Re: ANCA Draft Regulatory Decision

I have studied the ANCA section on Fingal Co Council's website, including the Draft Regulatory Decision and also watched two online webinar sessions. I wish to lodge my observations and objection to the Draft Regulatory Decision.

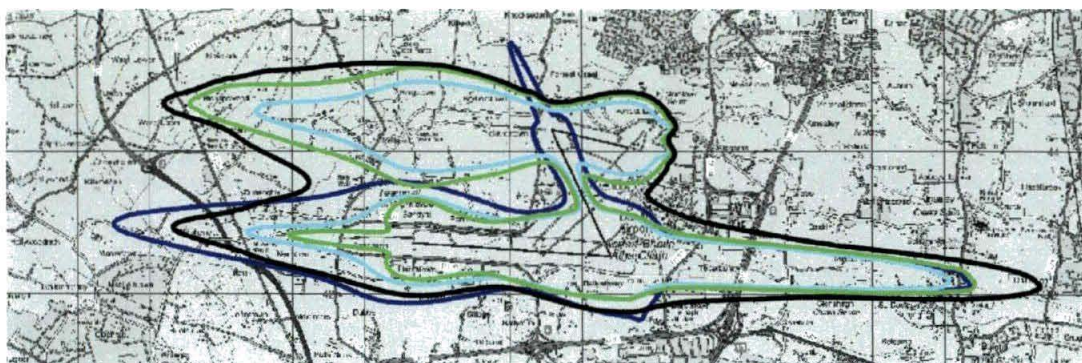
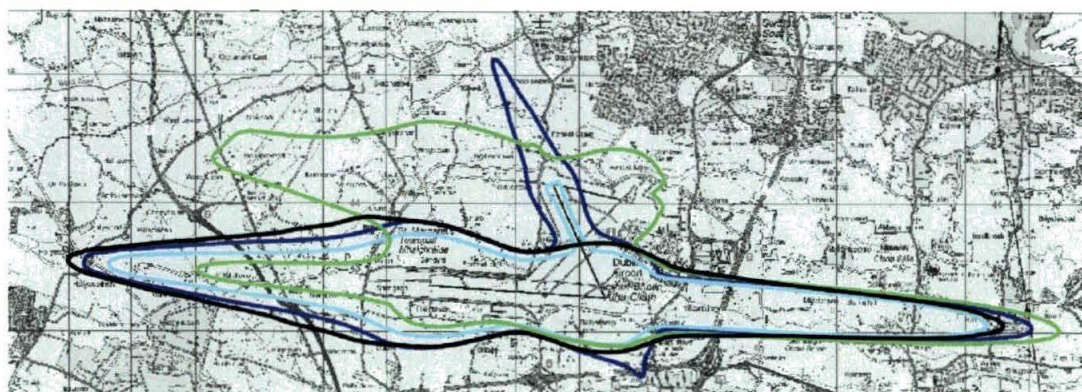
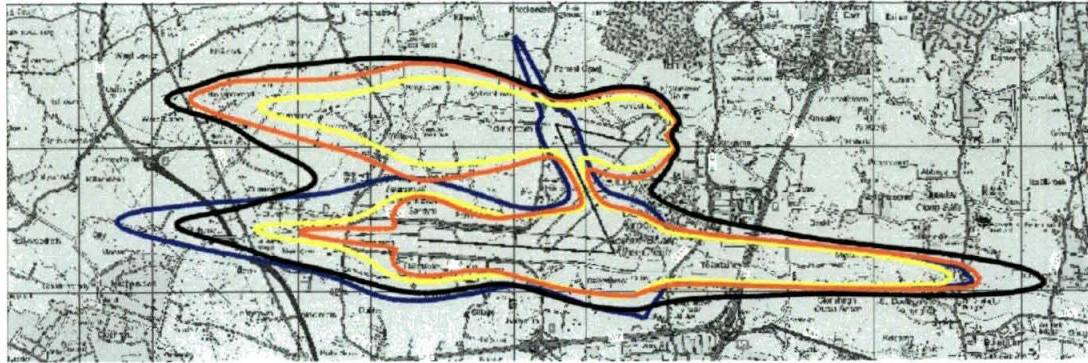
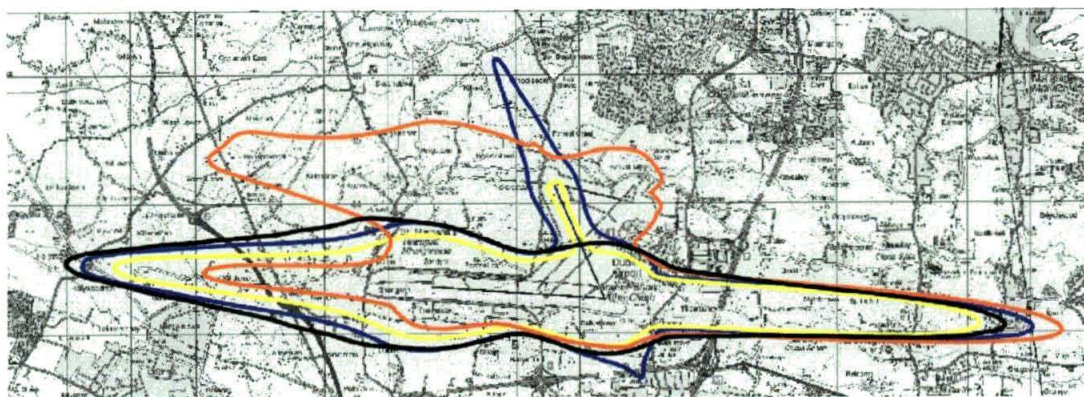
4. Noise Maps shown by the applicants ignore flight path divergence required by the Irish Aviation control.

All the noise maps presented (included in the ANCA documents) show direct parallel operation of take-offs and landings. However, officially under Instrument Flight Rules (IFR) **"if both main runways are in operation the departure tracks must diverge by at least 15 degrees immediately after take-off"**. (in order to avoid crashes). Although in local public consultations this issue was referred to and some divergences were shown impacting mainly in the Northern track, this matter was not addressed in the current application or by ANCA. Although in the ordinary operation, Portmarnock Community School is shown to be affected. However, the likes of Malahide Community School and Scoil An Duinninigh at Feltrim Road/Kinsealy Court would be affected by the divergence in take-off. This is not obvious in the maps supplied in this Application, where divergence was not considered, nor is it considered by ANCA.
